From: [REDACTED]
Sent: 03 March 2019 11:28
To: Andrew Wood
Subject: planning application FG/220/18/PL New house in garden of Elm Lodge, Tamarisk Way, Ferring, BN12 5ER

Having carefully examined this application against the policies embedded in the Arun Local Plan, we believe that the application contravenes these policies in the following ways:-

PROPOSED WEST (SIDE) ELEVATION 1:50.

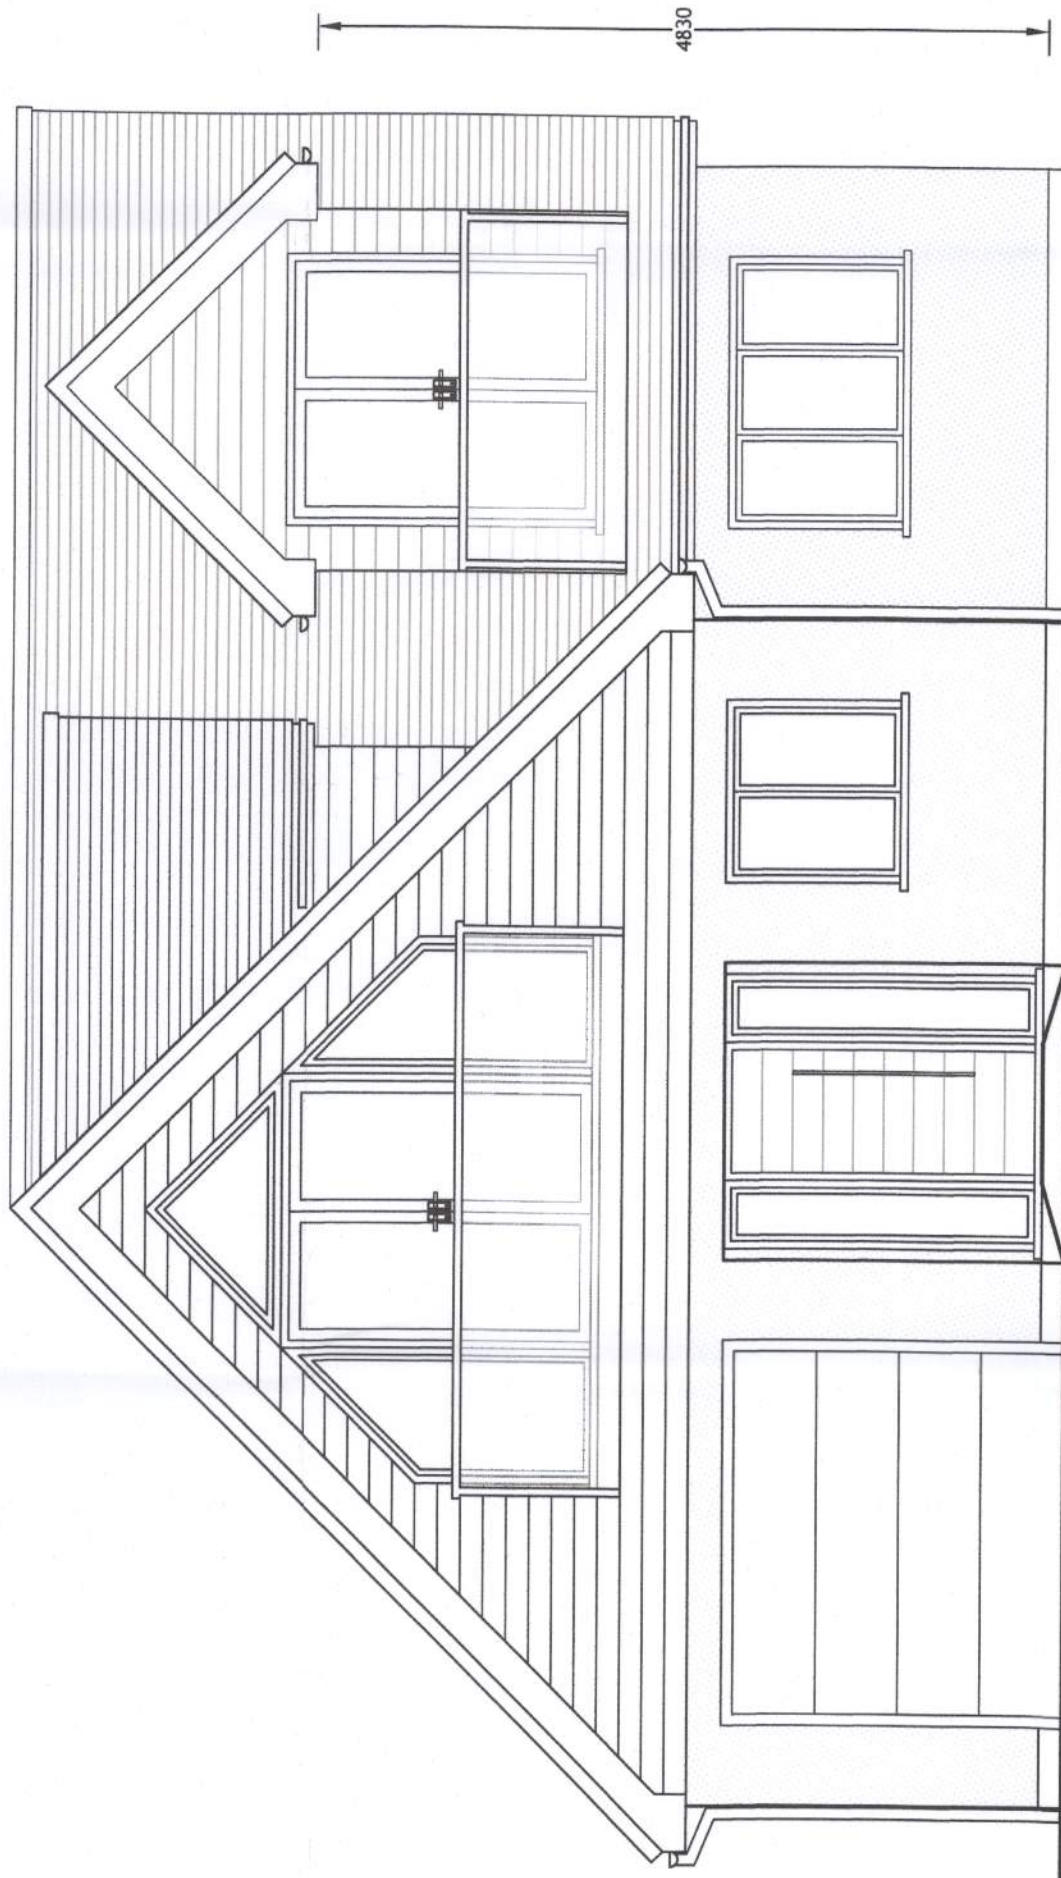
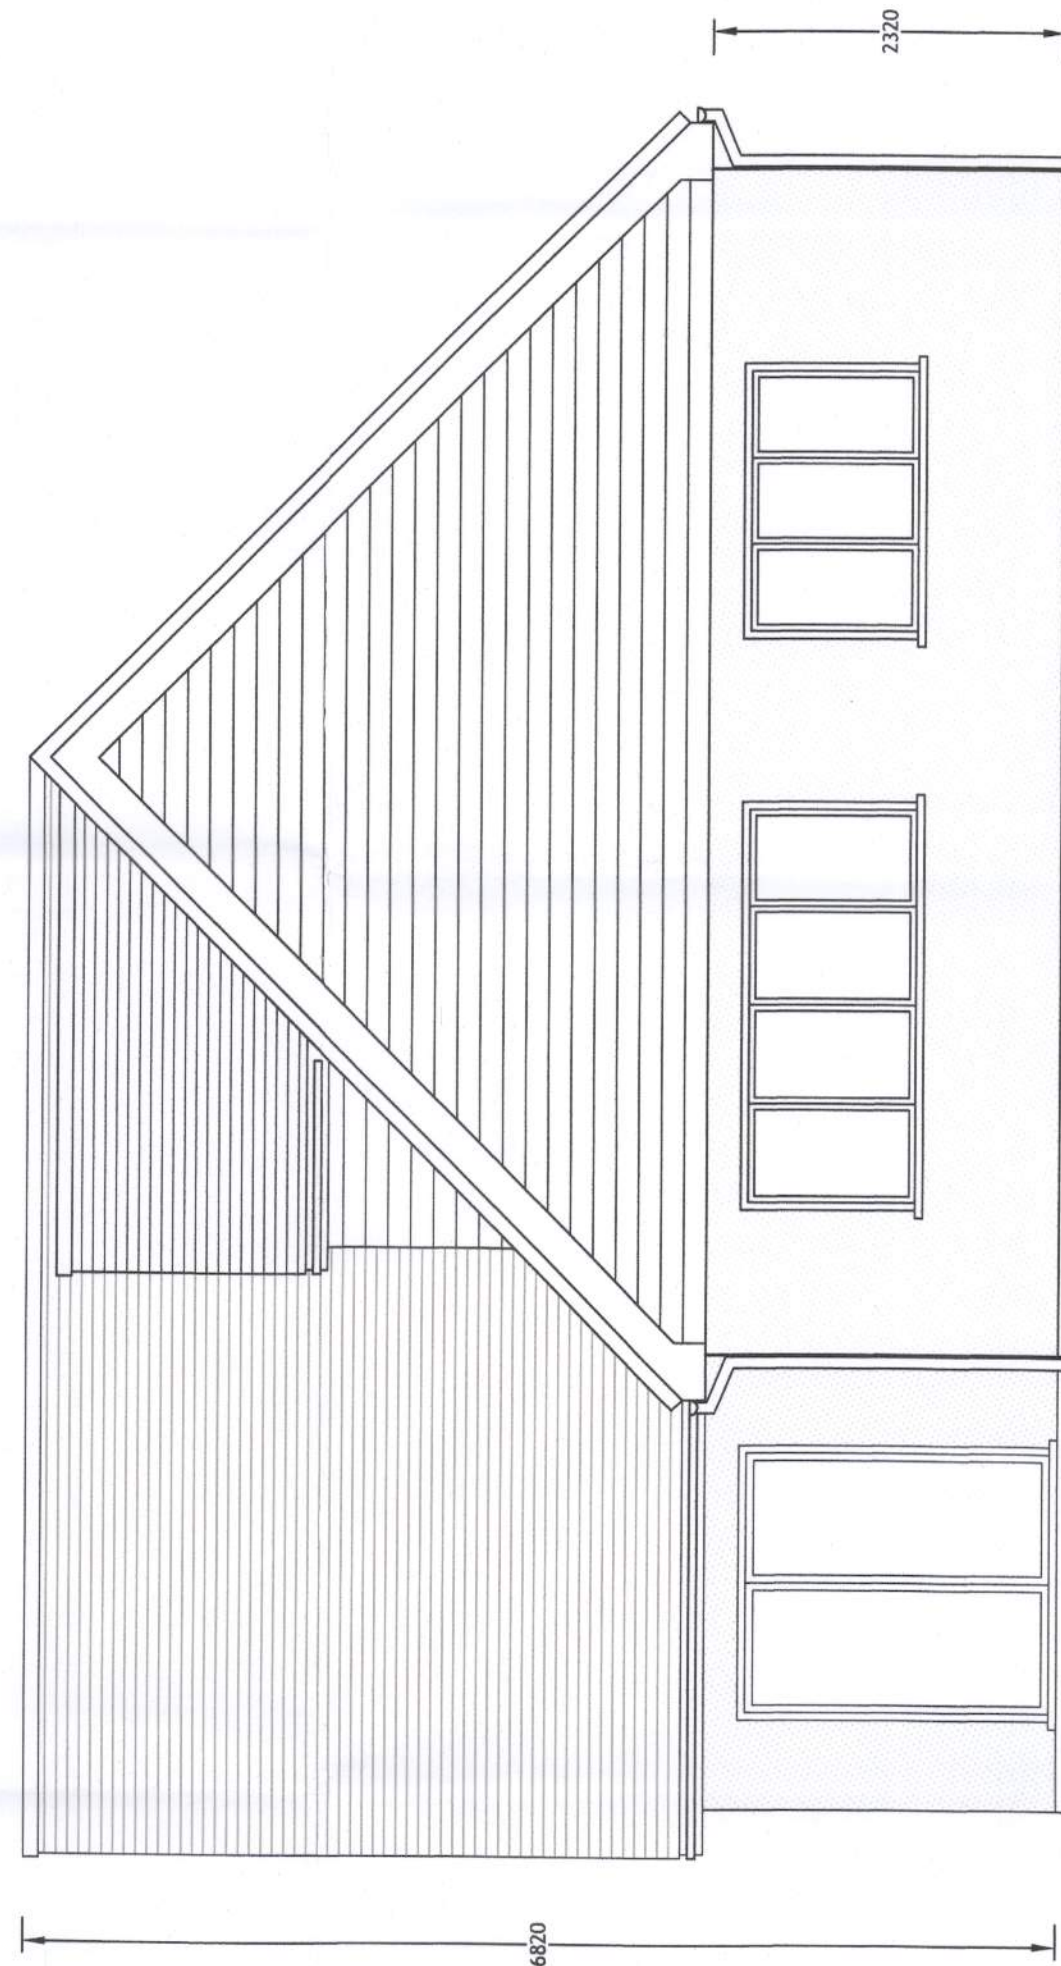
The proposed house plans call for 3 full length balcony windows on the first floor, 2 of which will look down directly into habitable areas and gardens of Magalia (one of these windows fully covers the entire 1st floor gable). We would point out that this is in addition to a third window which is to be installed in Elm Lodge and which is in fact less than the recommended distance from Magalia (see discussions held at a site visit from a member of the Arun Planning Dept. in November last year). This presents an excessive and unacceptable intrusion of privacy and we believe this to be contrary to the requirements of the Arun Local plan as detailed above

The ‘post- modern’ style of the proposed house and alterations to Elm Lodge are highly suitable for the urban Home Counties, but are completely out of character and sympathy with the houses in and around Tamarisk Way and along Sea Lane. The use of cladding, blue slate tiles and grey windows bears no resemblance to any building materials used in the vicinity of Tamarisk Way and would stand out like a ‘sore thumb’.

PROPOSED POND ACCESS
PLAN

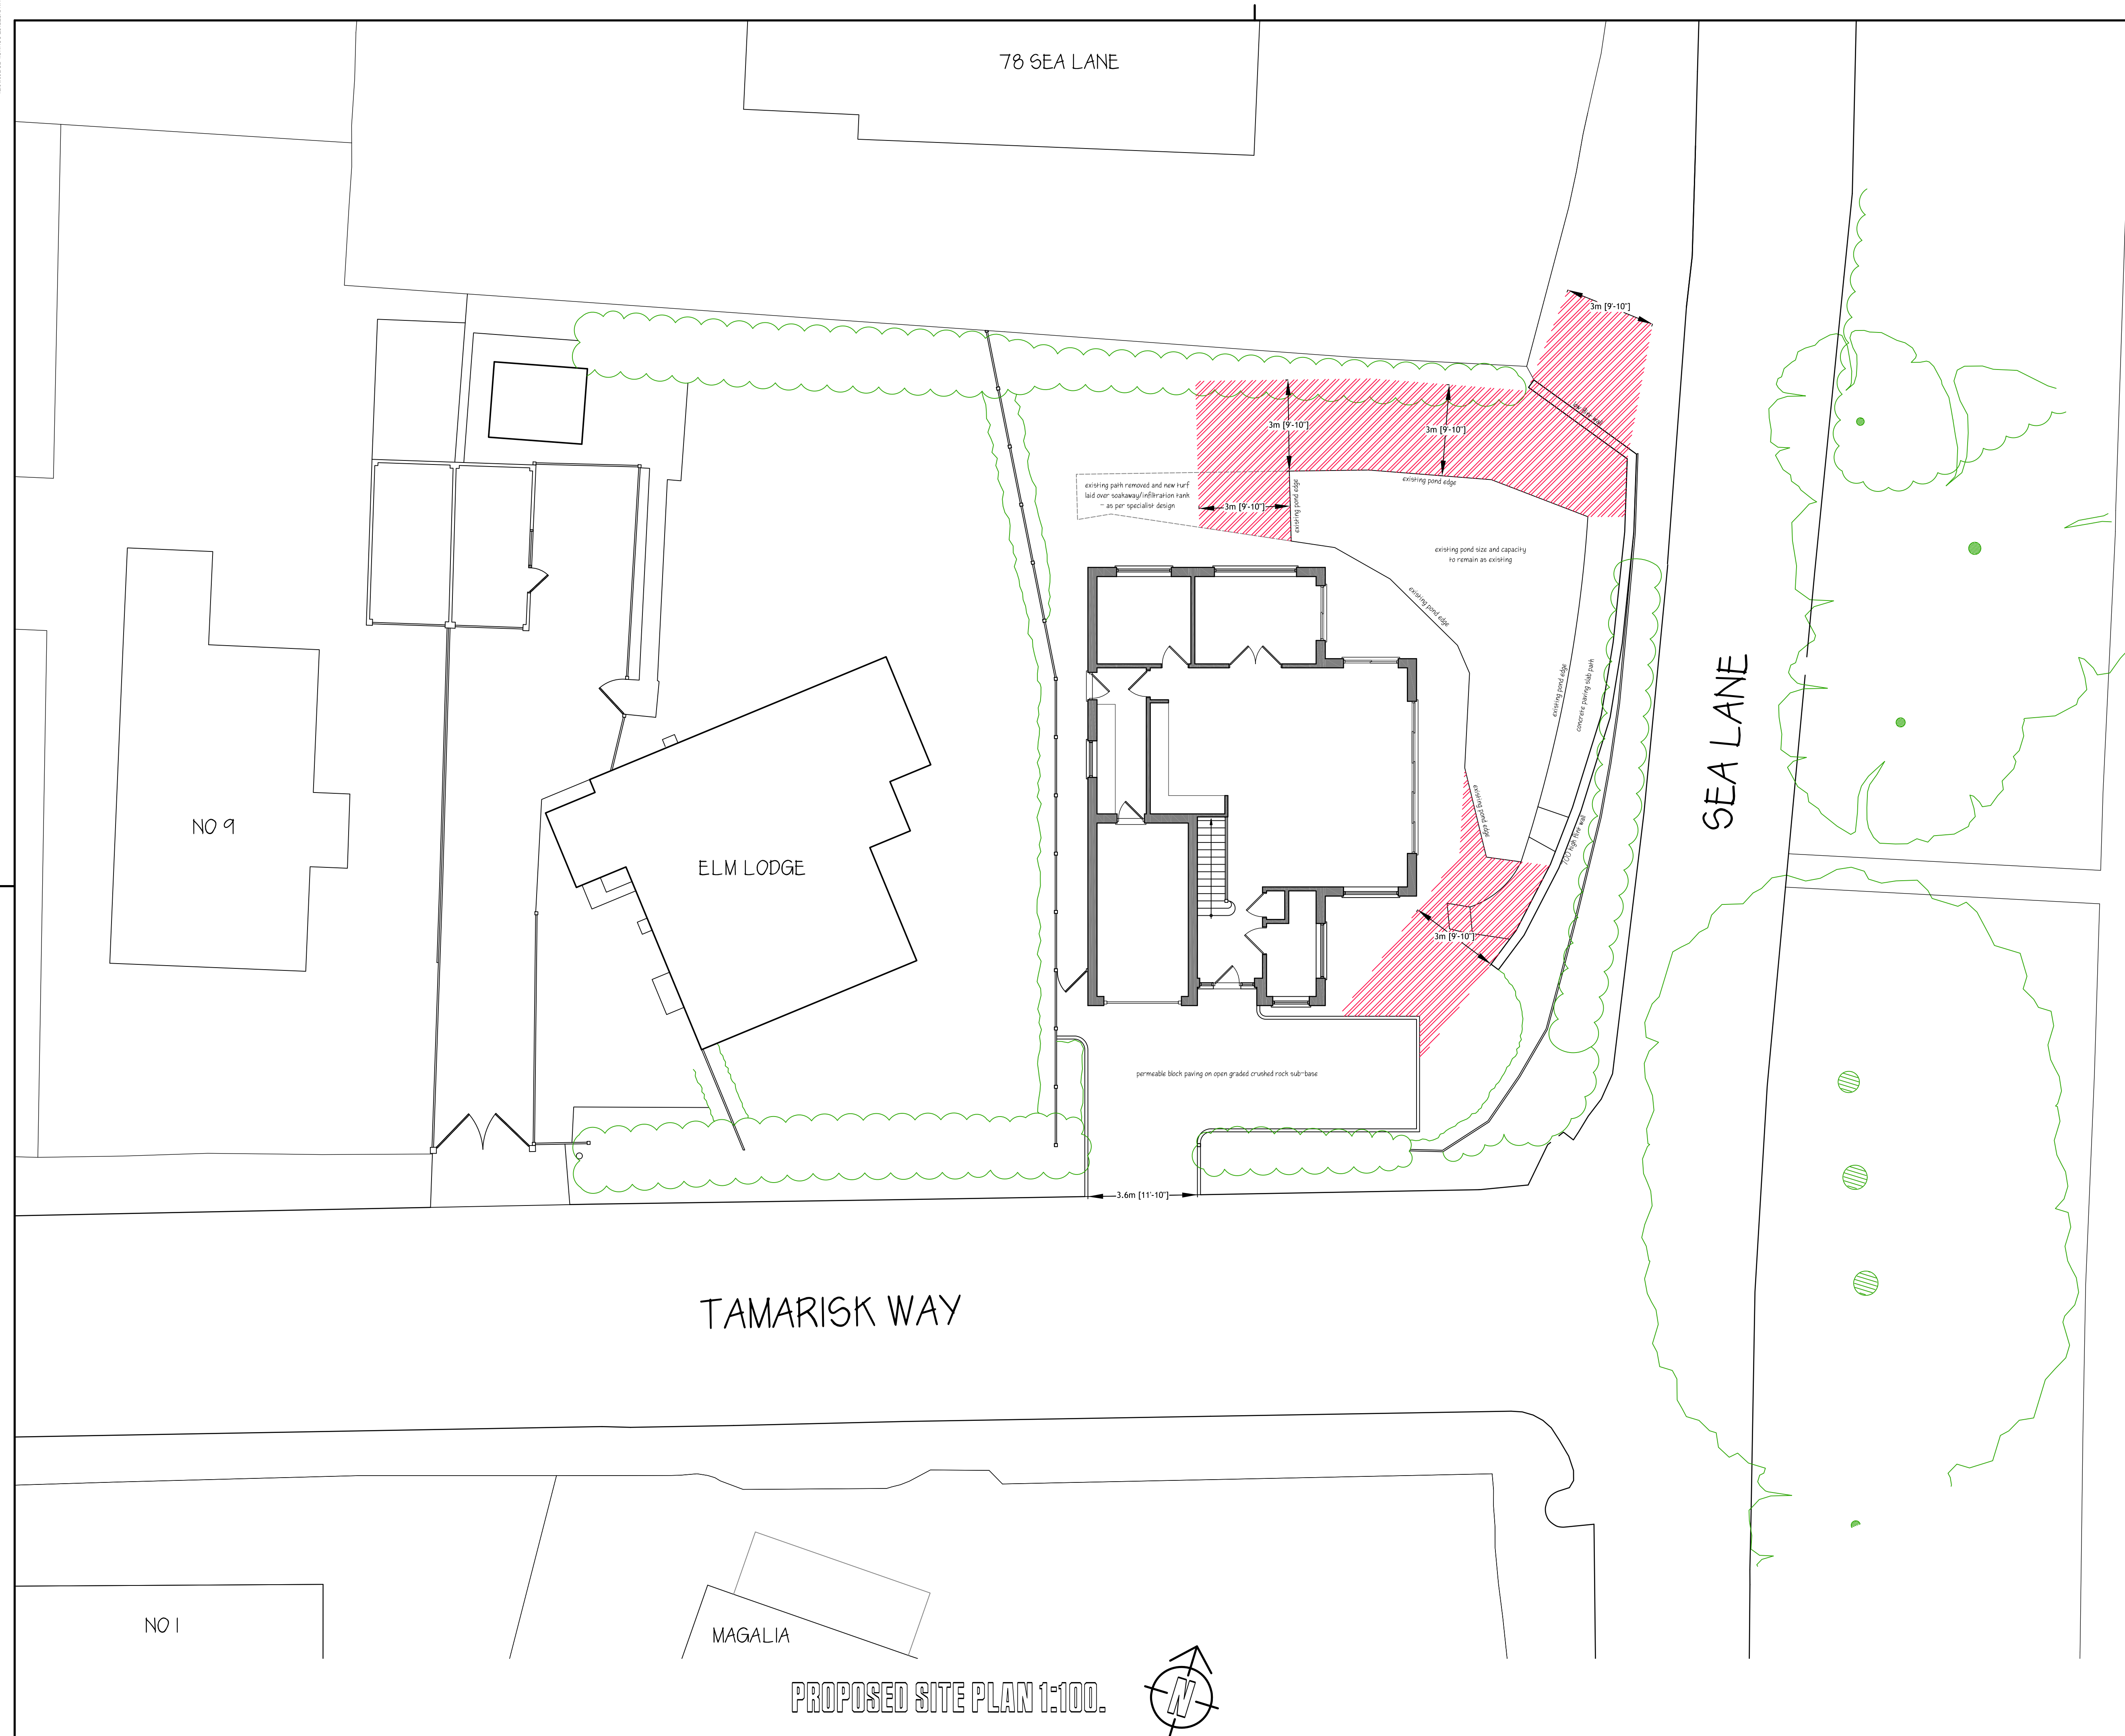
Examining the exchange of correspondence regarding drainage, we note that it seems to give greater emphasis to technical rather than practical matters. We would draw attention to the fact that 2018 was an exceptionally dry year and our experiences show that following heavy rainfall, the surrounding area does indeed flood, as demonstrated by the pictures attached to correspondence dated 15th February 2019

The drainage both on land and road in the immediate vicinity and South Ferring is via the pond, a small number of ditches and two roadside soakaways. We would submit that greater consideration must be given to the fact that covering the ground by building will inhibit the natural absorption of rainfall by natural means.
